MORGAN AND MORECAMBE OFFSHORE WIND FARMS: TRANSMISSION ASSETS

Annex 3.5 to Applicants' Response to WRs: The Wildlife Trust for Lancashire, Manchester and North Merseyside

Deadline: Deadline 2
Application Reference: EN020028

Document Reference: S_D2_3.5
5 June 2025
F01

**Figure 1.3: NVC digitisation of Fylde sand dunes (from Skelcher (2016))**

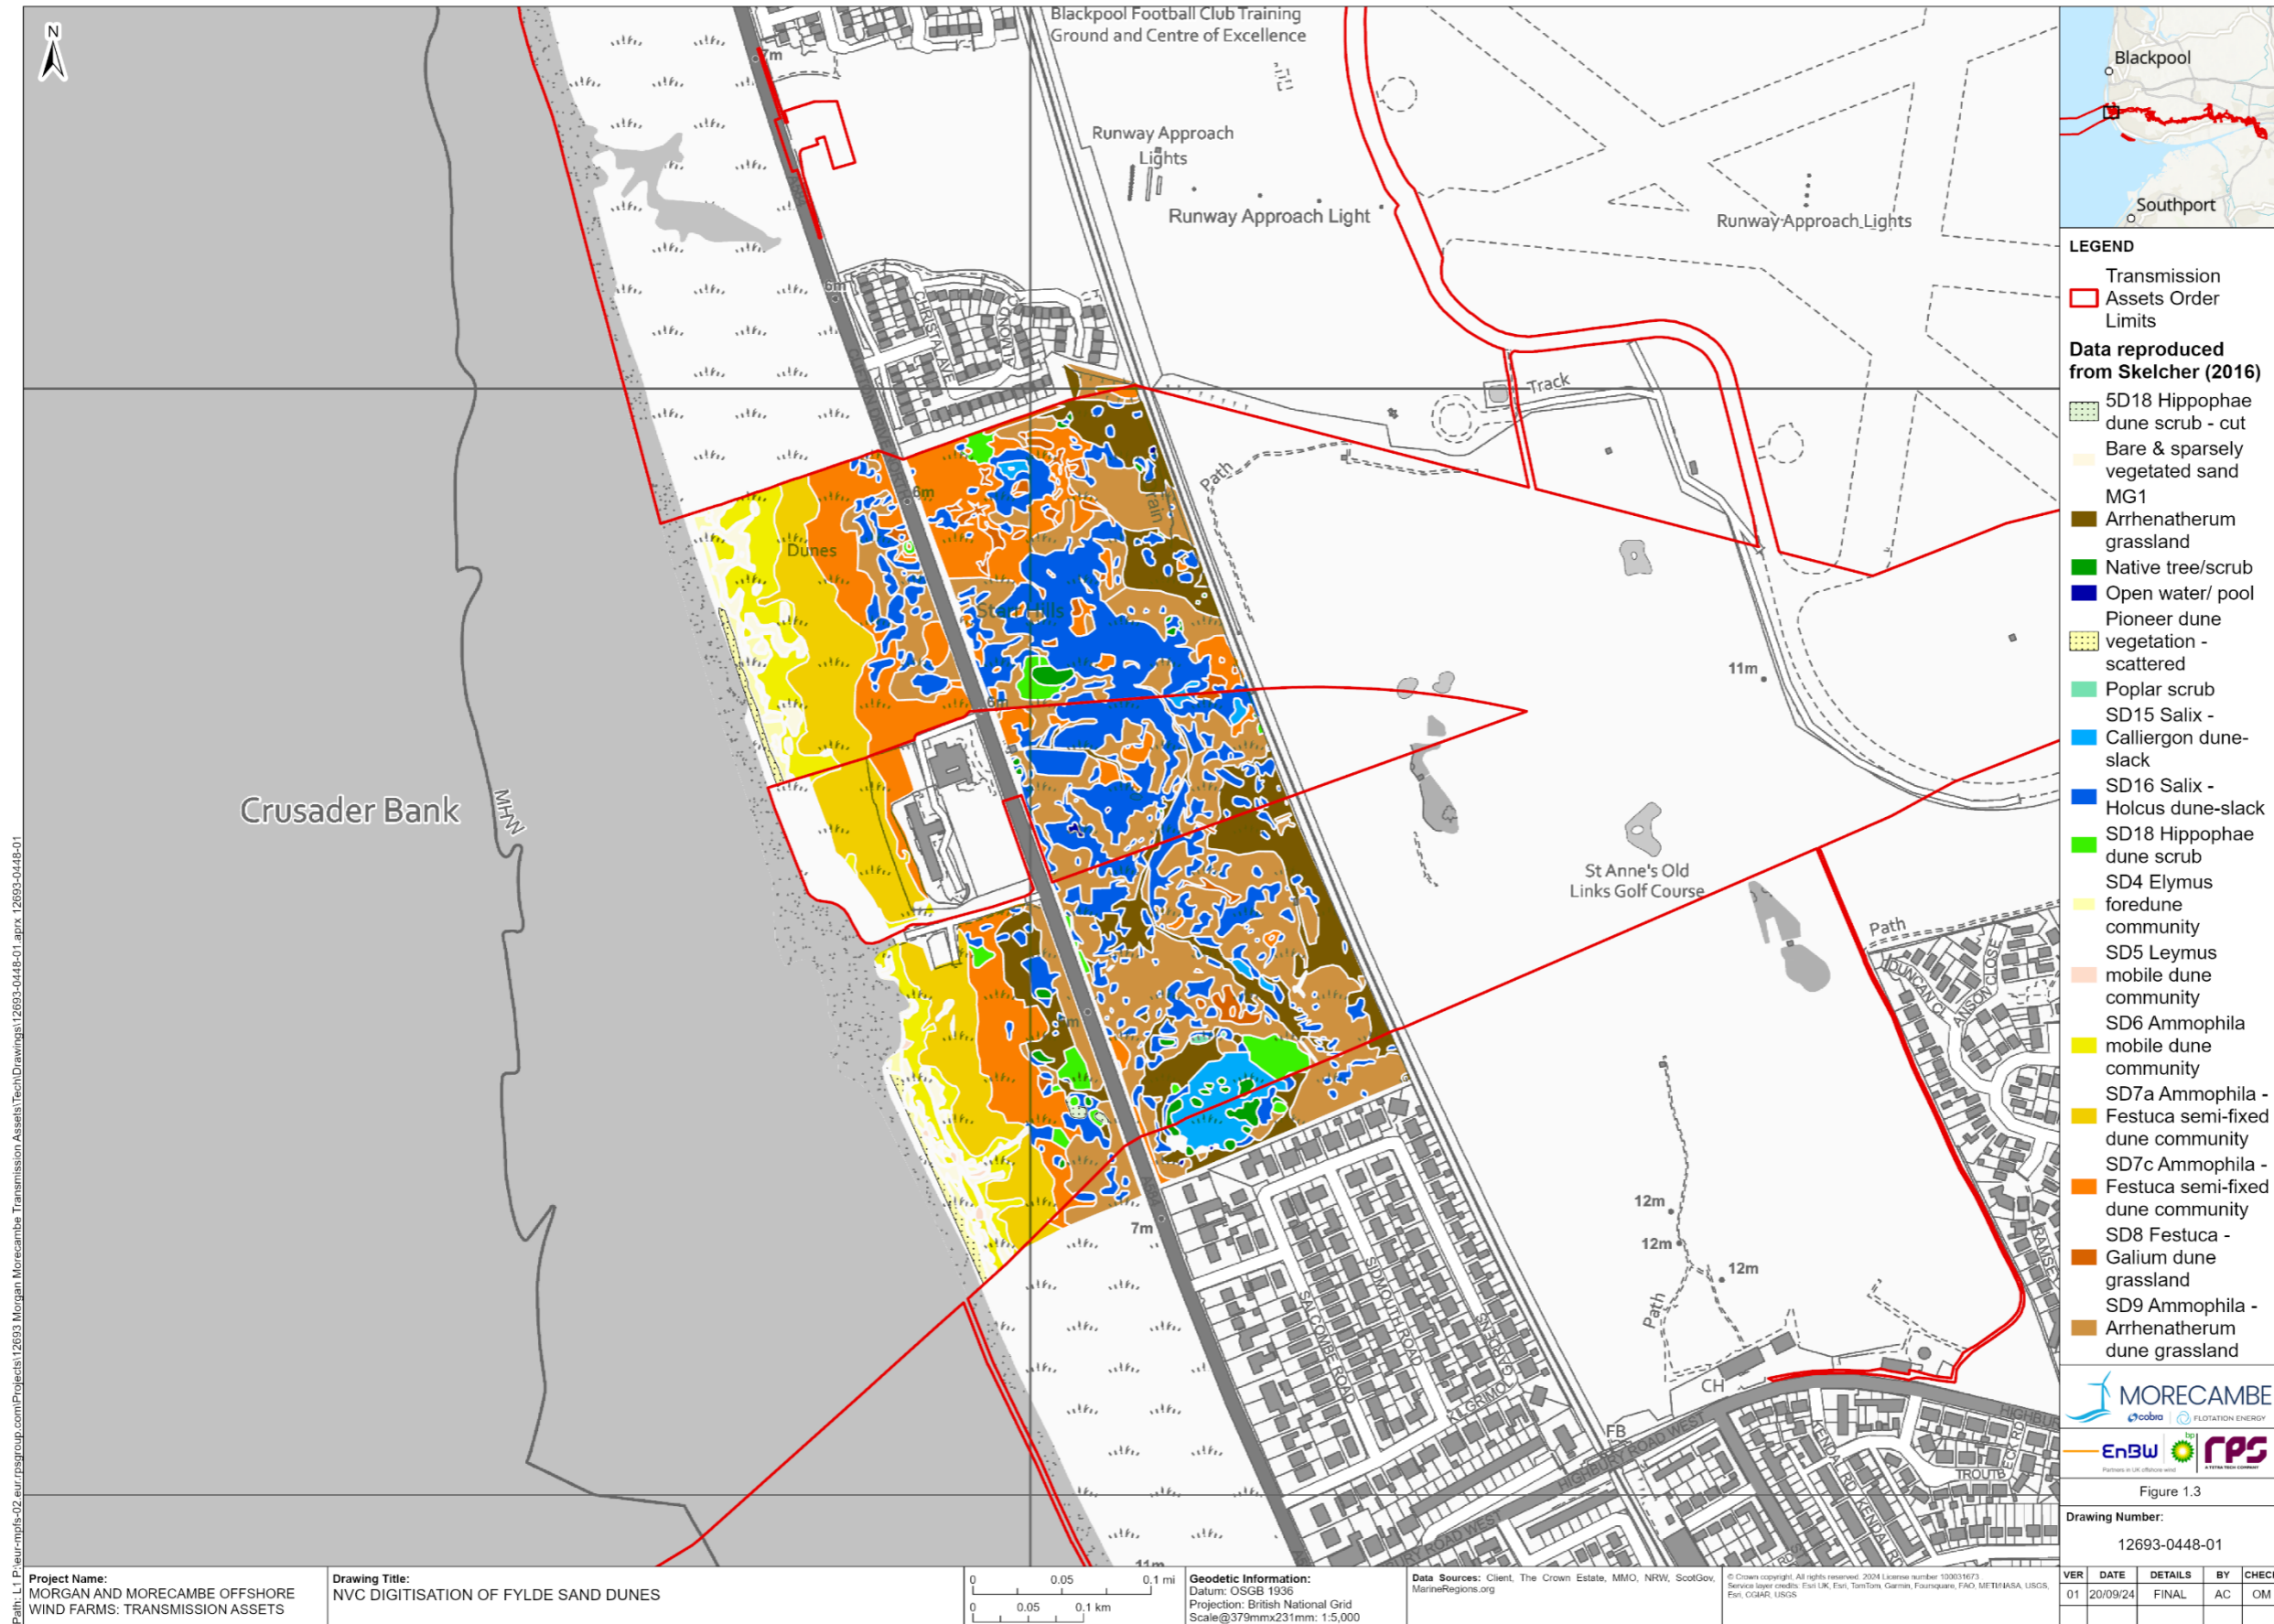
Reference	Written Representation Comment	Applicants' response
REP1-210 210.14	<p>Inadequate data and errors in habitat mapping: Dunes Project staff have identified that several areas of habitat on the Local Nature Reserve (LNR) have been wrongly mapped, e.g. dune slack areas mapped as scrub. This accuracy matters as it means that the site and ecological impacts may have been incorrectly assessed with scrub being less susceptible to hydrological influence than dune slacks. Key species have also been missed or vastly under recorded, e.g. Smooth Newt and hundreds of Common Toad. There is a significant under recording of all species that have been presented on the maps, data could have been made available from the Dunes Project but was not requested. There is no specific species data for both insects and plants. Considering the ecological importance of the area and the rare and endemic species present (e.g. the sole surviving specimen of the nationally rare Hybrid Willow (<i>Salix x friesiana</i>)), these should have been identified within the environmental assessment.</p> <p>We note that Natural England also have similar concerns (G17) regarding data gaps and the consequent difficulty in accurately assessing ecological impacts arising from the proposed development, most especially in relation to water table change impacting humid dune slacks.</p>	<p>The Applicants note that data on amphibians and reptiles within the sand dunes was helpfully provided by the Fylde Sand Dunes project to inform the ecological baseline, as referenced in Table 3.6 of Volume 3, Chapter 3, Onshore Ecology and Nature Conservation (APP-075), particularly in relation to the sand lizard population, which is well monitored at this location since the introduction took place.</p> <p>The habitat mapping of the sand dunes that informed the impact assessment was primarily informed by the 2016 NVC survey undertaken by botanical specialist Graeme Skelcher, with a ground truthing botanical NVC survey undertaken by the Project in summer 2024.</p> <p>Given that the project will not directly impact the dune habitats (due to the use of trenchless crossing techniques), and that impacts on the hydrology were not considered to be significant due to the depth of the trenching and the offsetting from dewatering activities associated with the exit pits and transition joint bays, it was not considered necessary or proportionate to undertake a detailed suite of amphibian, reptile or terrestrial invertebrate surveys. The scope of ecology surveys was agreed at an early stage of the project with key stakeholders and discussed at Expert Working Group (EWG) meetings, as detailed in Appendix G of Technical Engagement Plan Appendices Part 2 of 3 (APP-191). However, regardless of this, the ecological value and sensitivity of the dune habitats and the animal and plant species they support are well documented and further surveys undertaken by the Applicants would not have changed the evaluation of their importance to nature conservation, or the conclusions of the impact assessment.</p> <p>To address concerns about potential indirect effects to the dune habitats as a result of the trenchless crossing the Applicants are preparing further information (to be submitted at Deadline 3). Further details are provided above in REP1-210 210.12.</p>
